# Heckington Fen Solar Park

## Environmental Statement | Volume 3: Technical Appendices Appendix 6.10: Summary of Section 42 Consultation Responses Since PIER

Applicant: Ecotricity (Heck Fen Solar) Limited

**APPENDIX 6.10- SUMMARY OF SECTION 42  
CONSULTATION RESPONSES SINCE PEIR**

FIGURE 6.5c SCREENED ZONE OF THEORETICAL VISIBILITY - NATIONAL GRID BICKER FEN SUBSTATION EXTENSION WORKS AND PROPOSED VIEWPOINT LOCATIONS PLAN

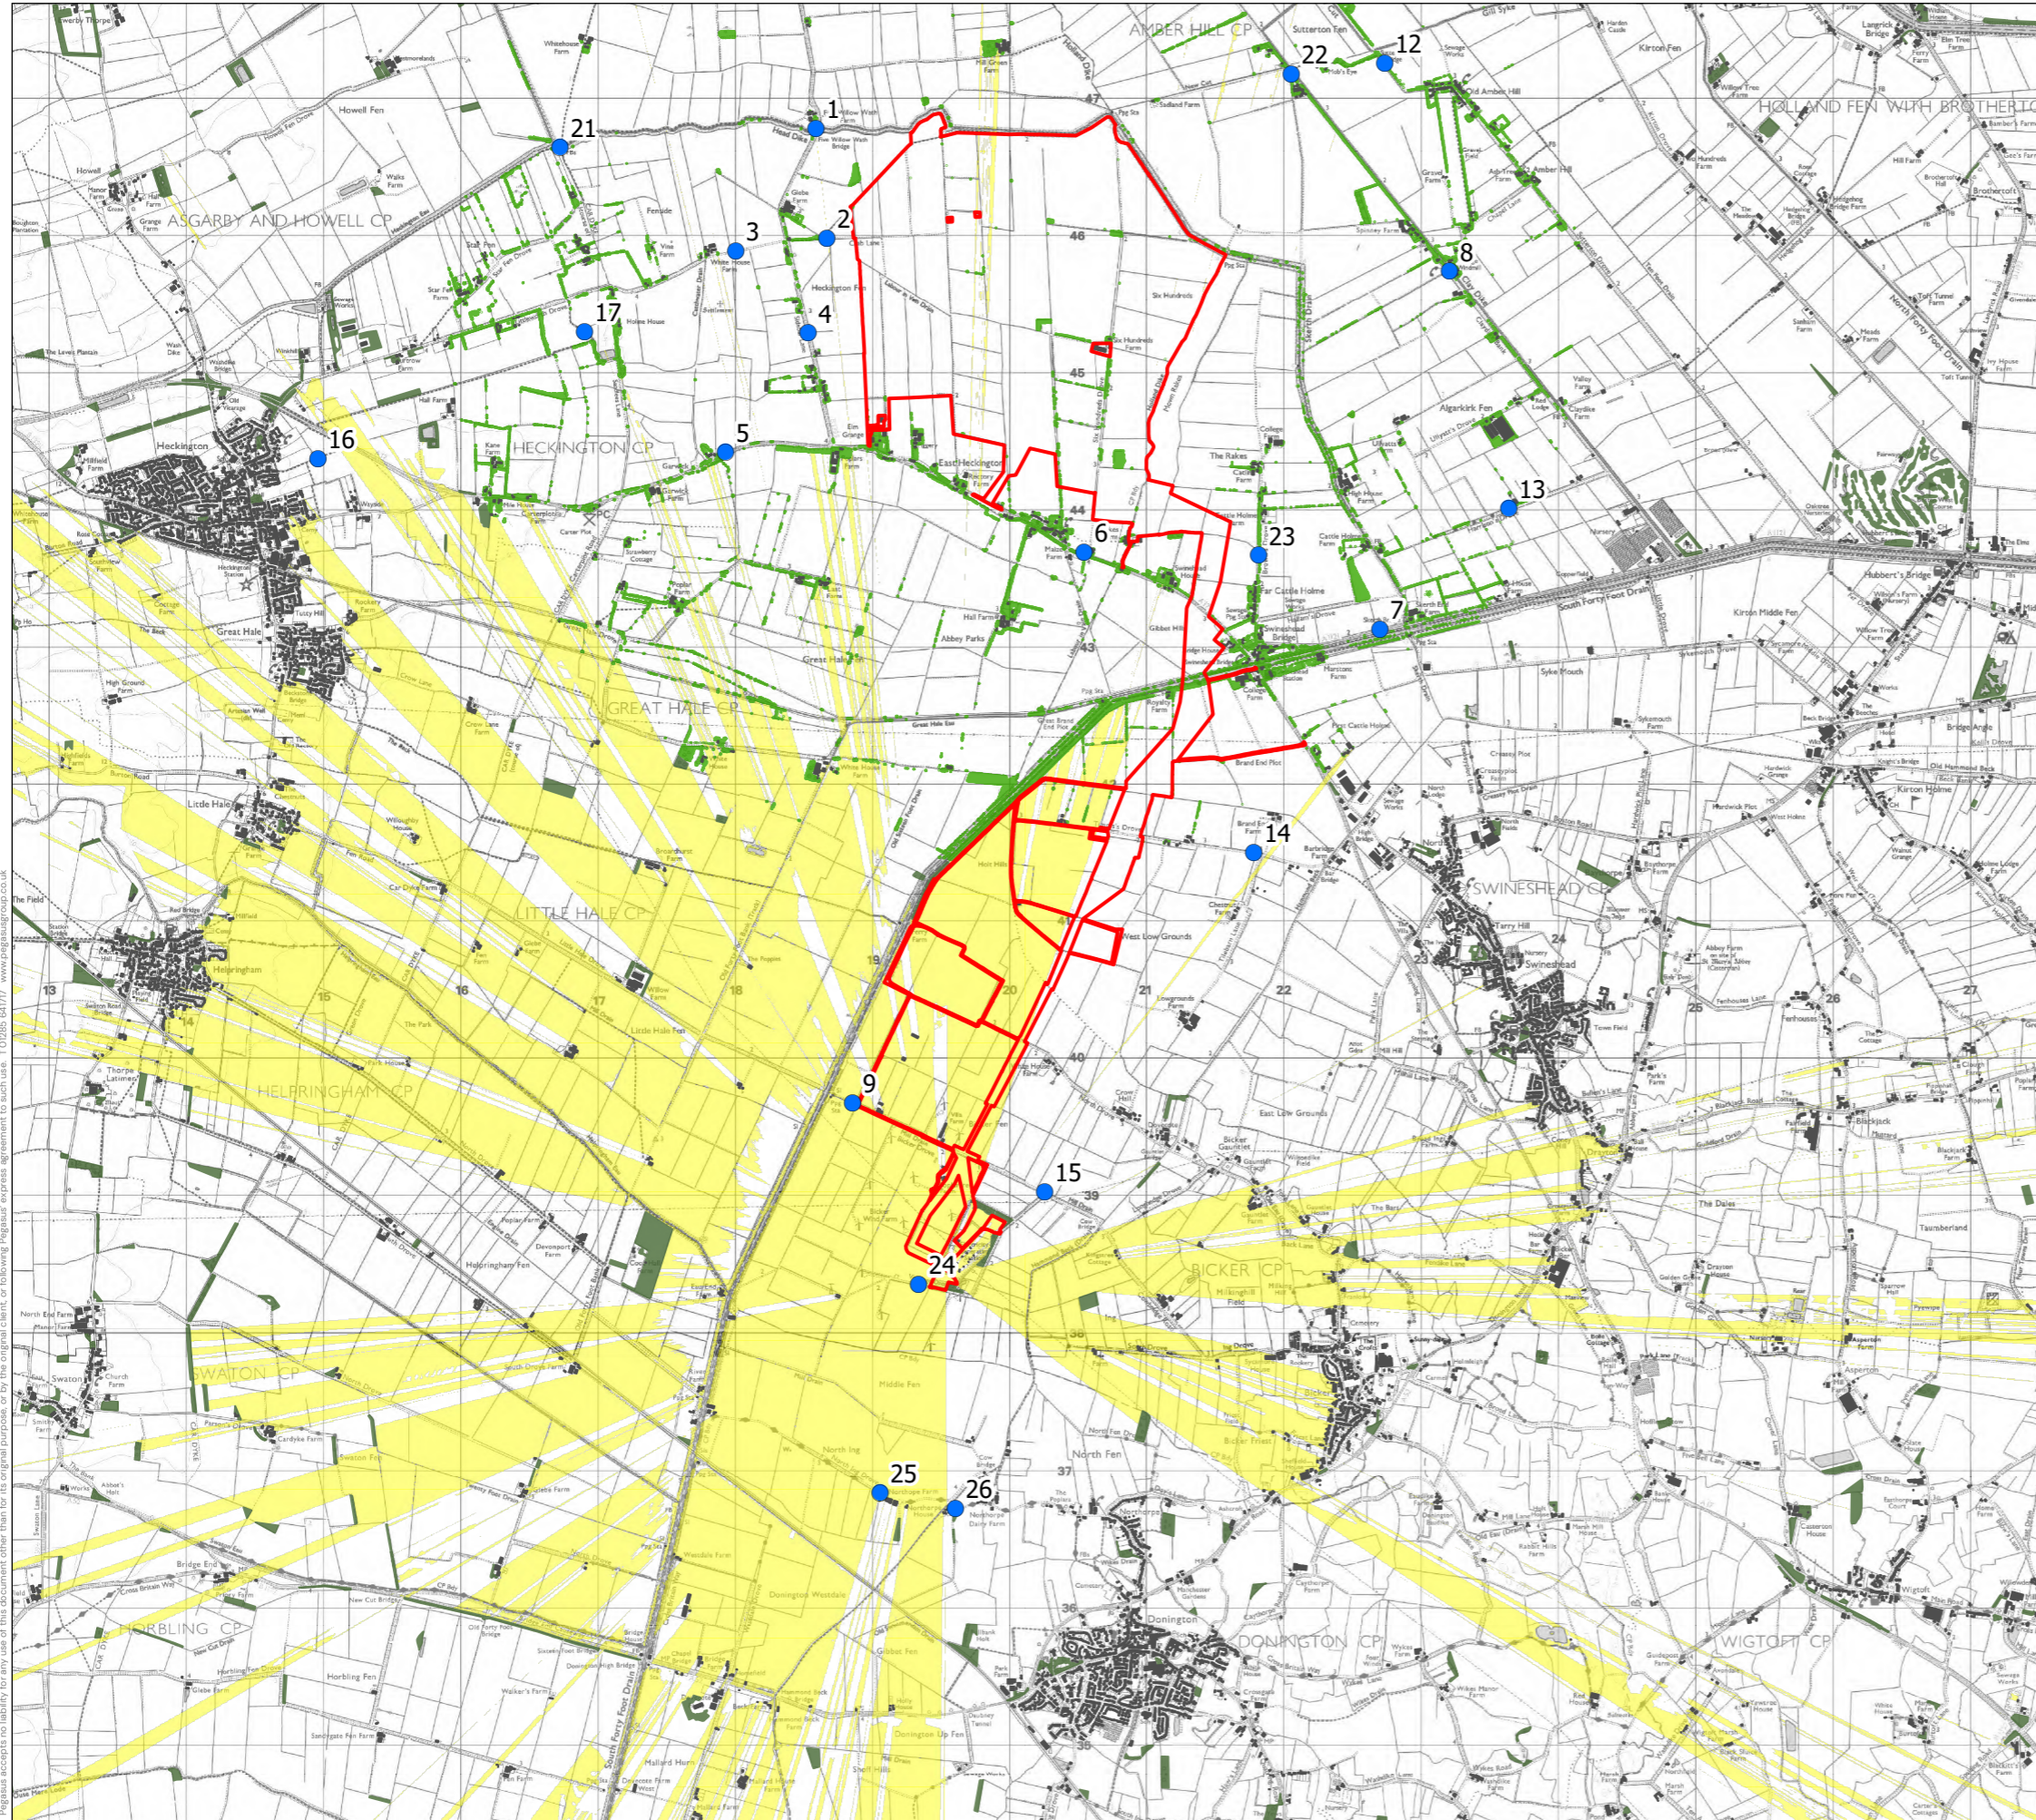
<p>Concerns with regards to the larger and taller elements, such as the bunding (up to 6m), substation and Control Building Parameters as outlined in Table 4.3. The final location and layout of these elements will have likely greater visual effects in this flat, open rural landscape than PV panels.</p> <p>Updated ZTV expected, based upon these parameters and an understanding of the likely requirement for additional viewpoint photographs to capture views of the taller/larger elements which will be much more visible and conspicuous.</p> <p>Paragraphs 4.5.40 to 4.5.42 provide information on offsite cabling, the route of which is still being developed, and confirms that no above ground cabling is proposed off site. However we have concerns in regards to the visual and landscape impacts, as well as potential ecological impacts, where cables cross obstacles, such as watercourses or the train line, which we assume would be carried out by directional drilling to minimise effects, particularly at construction. This should be clearly stated and assessed as part of the assessment and existing landscape and ecological assets in these locations should be protected and surveyed if appropriate to ensure effects are minimised.</p>		<p><b>Figure 6.5a Screened Zone of Theoretical Visibility - Solar Areas and Proposed Viewpoint Locations Plan</b>(document reference 6.2.6).</p> <p><b>Figure 6.5b Screened Zone of Theoretical Visibility - Substation Equipment with EES and Proposed Viewpoint Locations Plan</b> (document reference 6.2.6).</p> <p><b>Figure 6.5c Screened Zone of Theoretical Visibility - National Grid Bicker Fen Substation Extension Works and Proposed Viewpoint Locations Plan</b> (document reference 6.2.6).</p>

<p>Paragraphs 4.5.43 to 4.5.45 provide information on the Bicker Fen Substation works. The ES should clearly state the proposed works in this location as they have likely landscape and visual effects, particularly if impacting existing trees, as referenced within paragraph 4.5.45. At this stage, limited viewpoints have been proposed in this location, and once works are understood, we would suggest consultation is carried out with AAH/LCC and the district councils to ascertain any additional viewpoint requirements to assess visual effects.</p> <p>Mitigation proposals are provided in Table 4.3, which identifies Biodiversity Net Gain Area and Community Orchard. While these areas are shown on illustrative layouts, having these included in the design parameters allows for them to be accurately captured as part of the scheme, and parameters plan clearly illustrating these areas would be recommended. Figures 4.1C , 4.1 D and 4.1E appear to be good examples of plans to submit as potential parameter plans to accompany the design parameters tables. This would allow for transparency and clarity of development areas, areas of taller/larger development and mitigation when reviewing the LVIA and allow for an understanding of how the development has been assessed.</p>	<p>The design of the Proposed Development has been finalised. Further discussion with LCC took place; additional viewpoints scoped out.</p>	<p>The effects of the Off-site Cable Route Corridor and National Grid Bicker Fen Substation Extension Works are described in this <b>Chapter 6</b> (document reference 6.1.6).</p> <p>Comments with regard the orchard and parameters plan are noted, refer to <b>Figure 2.1</b> Indicative Site Layout.</p>
